# MEARS ASHBY PARISH COUNCIL

## Formal Written Representation and Statutory Objection to the Green Hill Solar Farm DCO Application (Ref: EN010170)

Title:
Figure 13.7: Location of Traffic Counts (North Area)

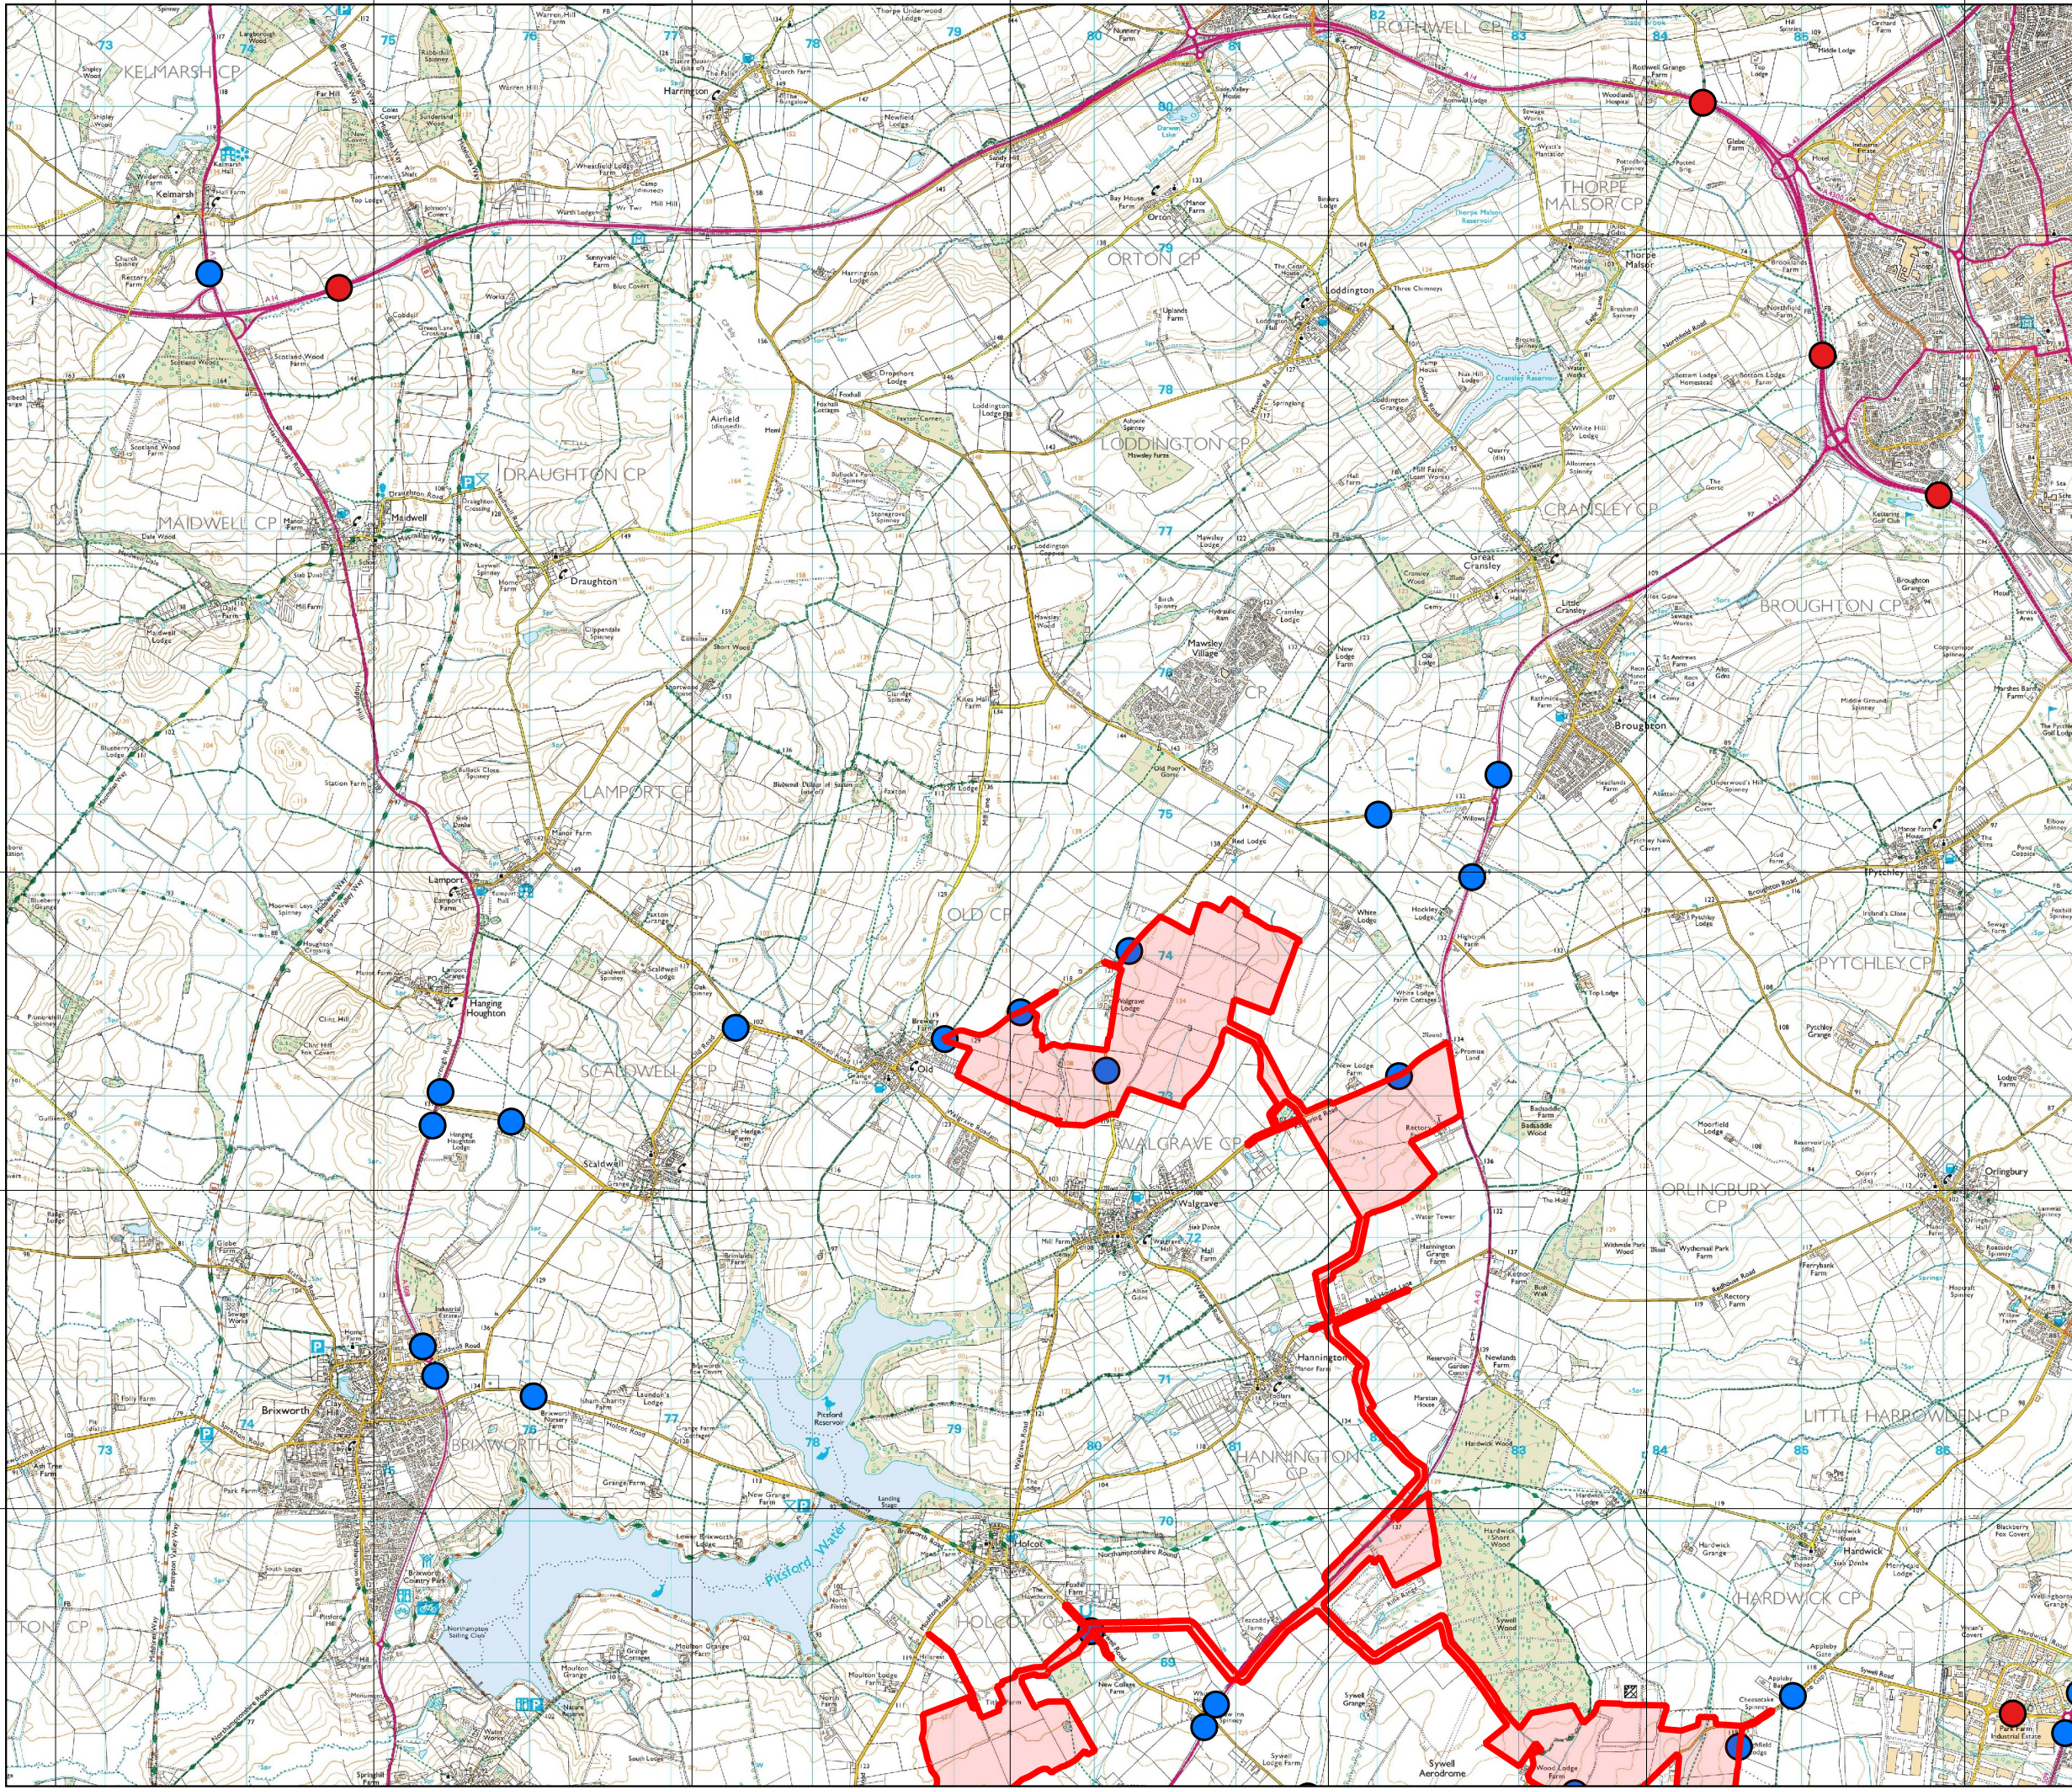
- **2.6 Highways Inadequacy and Severe Road Safety Risks (Wilby Road)**

The developer's Transport Assessment relies heavily on rural, minor routes for HGV construction traffic. Specifically, Wilby Road features acute blind bends, restricted width, and soft, uncurbed verges. This route lacks any pedestrian footpaths or cycle infrastructure. Introducing multi-ton HGV movements onto Wilby Road presents an unacceptable, severe risk to highway safety, active travel users, and structural road integrity—rendering the site logistically unsustainable during the prolonged construction phase.
